DECISION DELEGATED TO DEVELOPMENT MANAGER

Application No: H13-0026-21 **Applicant:** Mr & Mrs Ford

Proposal: Details of full photographic building recording, doors, windows and rooflights (Conditions 3, 4, 5 and 6 of H13-0865-20)

Location: 7 Broad Lane Moulton Spalding

ROOF WINDOWS - ROOF WINDOWS (NRW01, NRW02 & NRW03) TO BE 'VELUX CONSERVATION STYLE' FITTED FLUSH WITH ROOF FINISH AND FLASHING TO BE UNDER ROOF FINISH AS SHOWN. TO BE CENTRE PIVOT, SIZE TO BE 550x980mm.

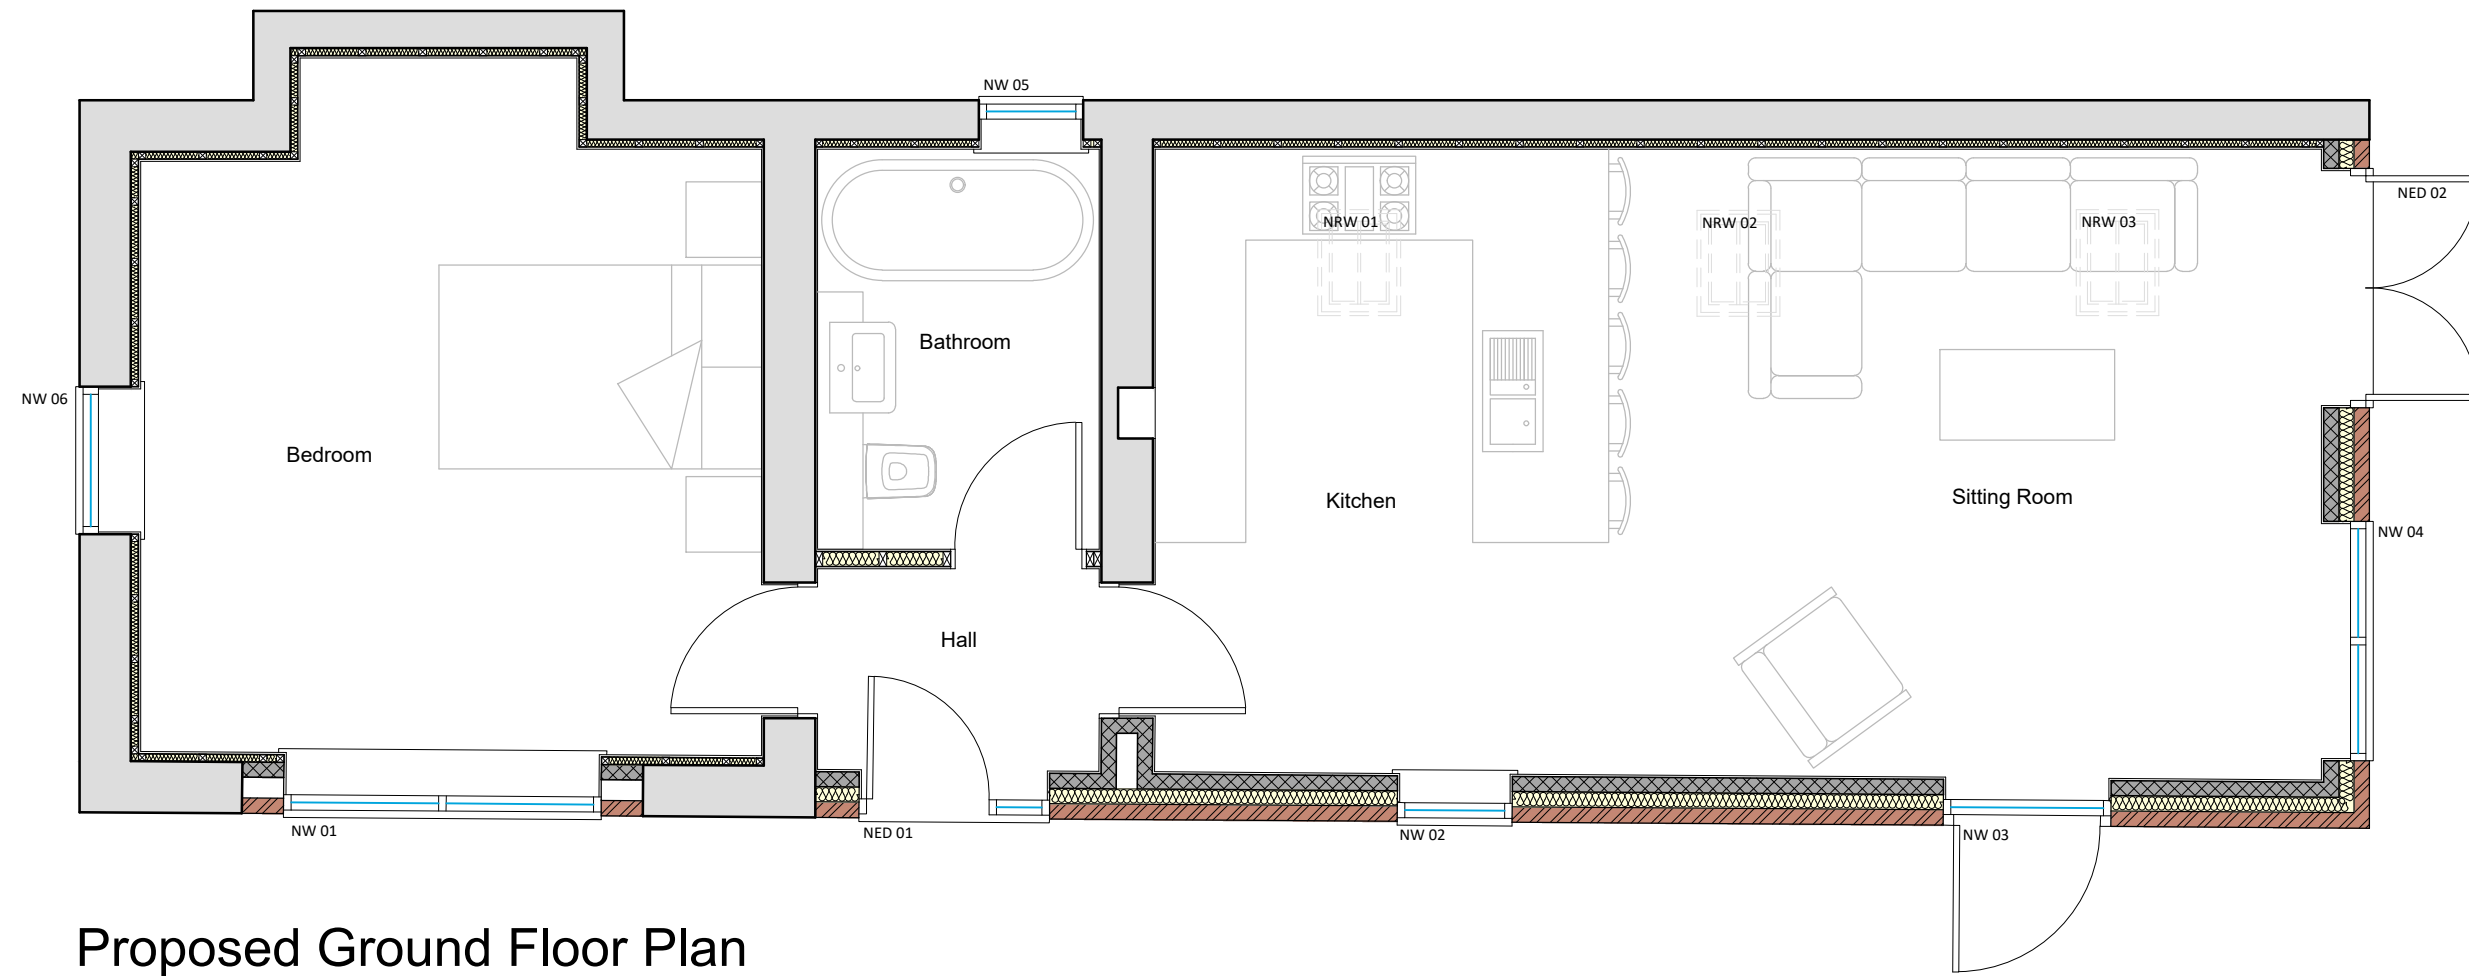
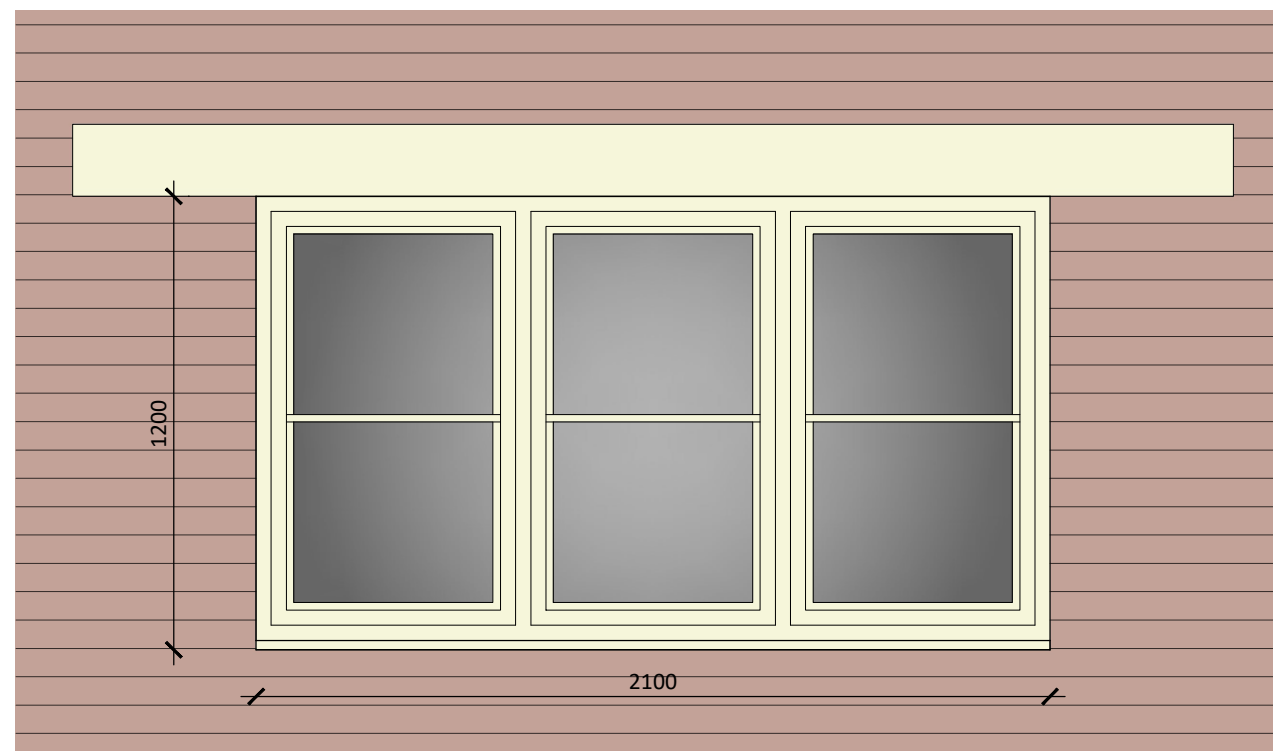
The details of the rooflights to be used have been presented and deemed by the local planning authority to be satisfactory due to the slimline, conservation style, flush sitting design, incorporating glazing bars. This condition, therefore, may be discharged.

Window 'NW01' Elevation
Scale 1:20

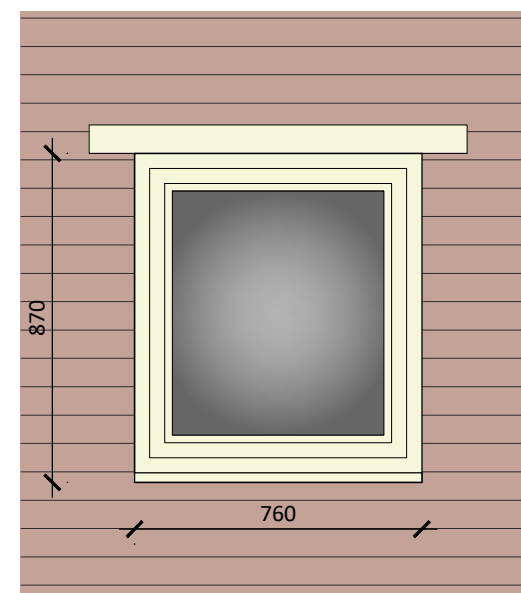
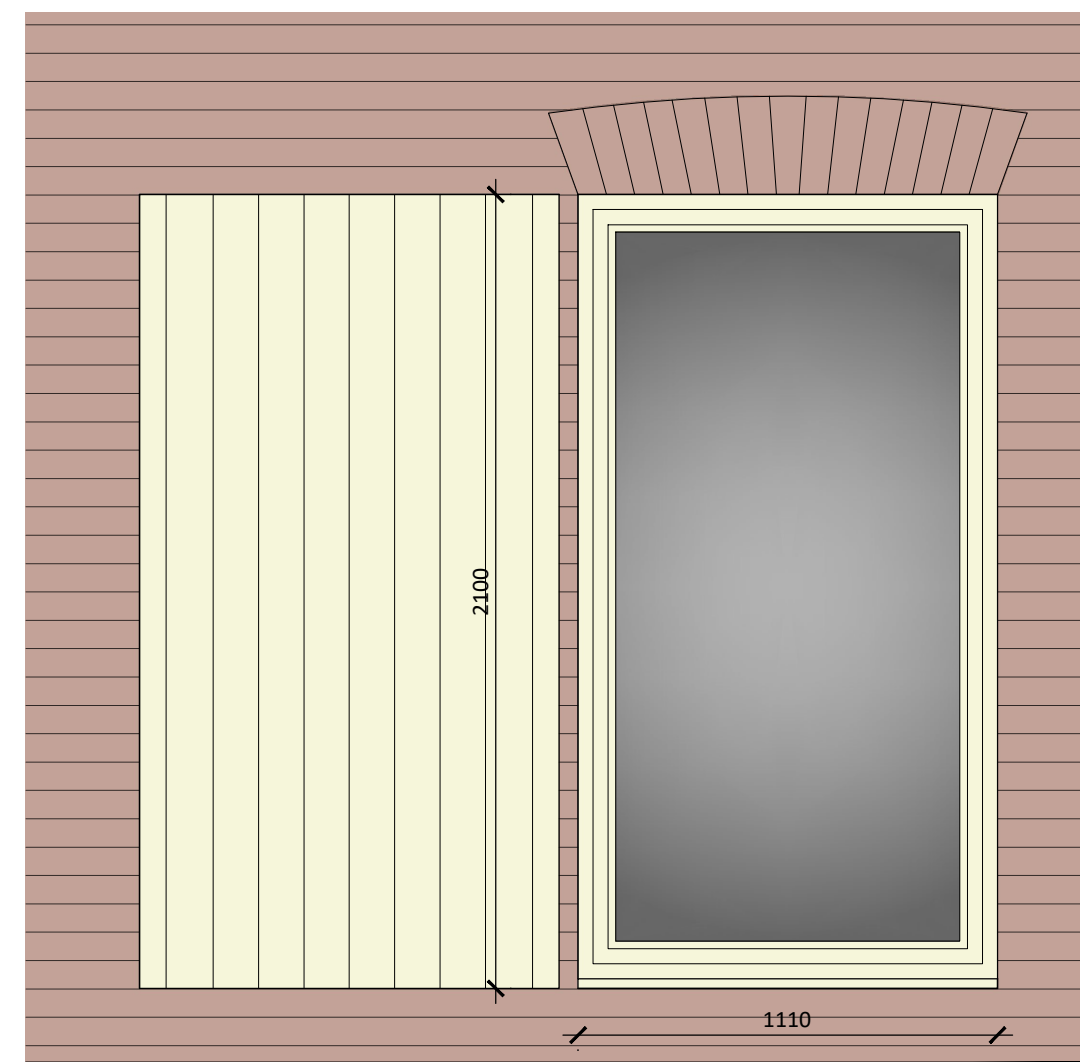
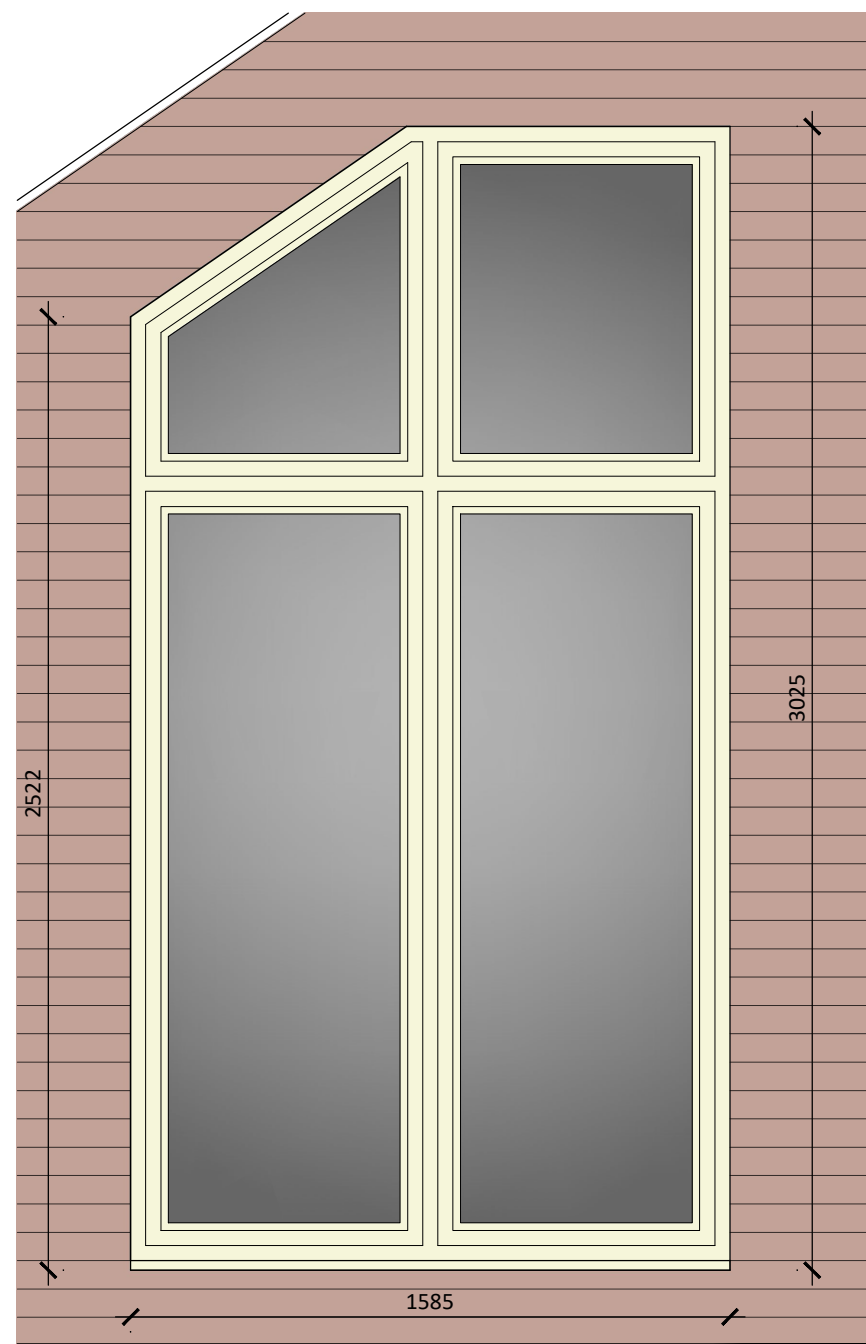
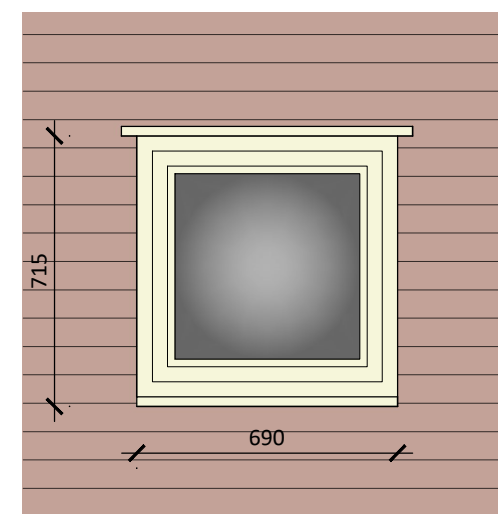
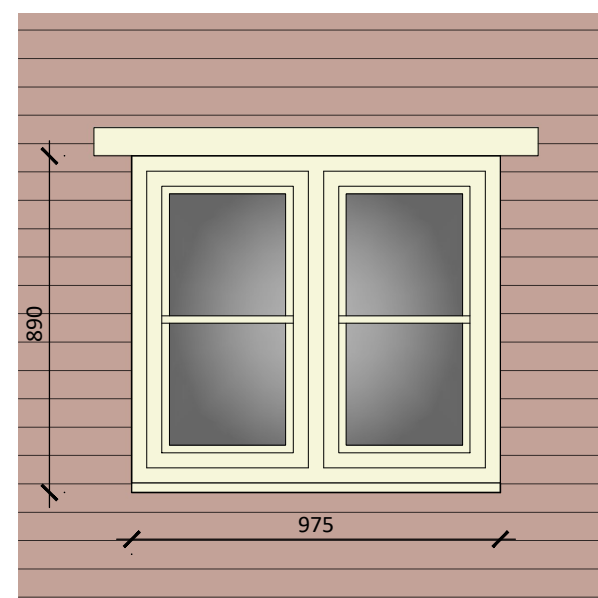
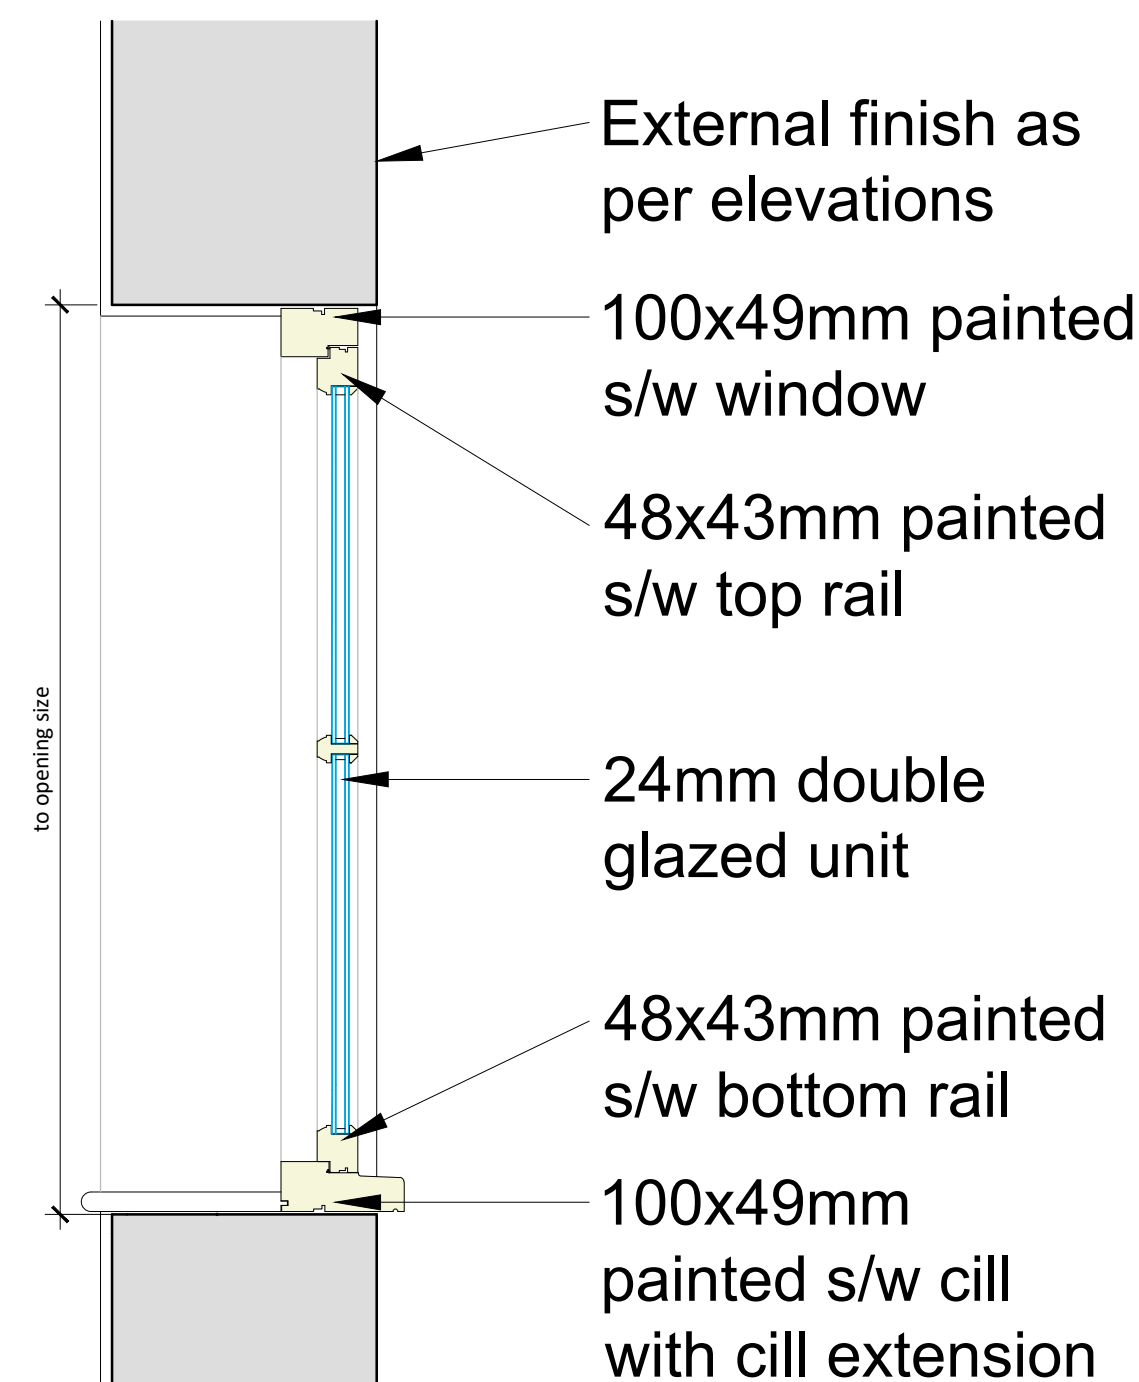
The details of the window frames to be used have been presented and deemed by the local planning authority to be satisfactory due to the timber nature of their construction and the slimline, conservation style assembly of the glazing. Furthermore, their design is deemed to be fully appropriate to the property, being of either mock-Victorian style with glazing bars or disguised as traditional barn-style doors. This condition, therefore, may be discharged.
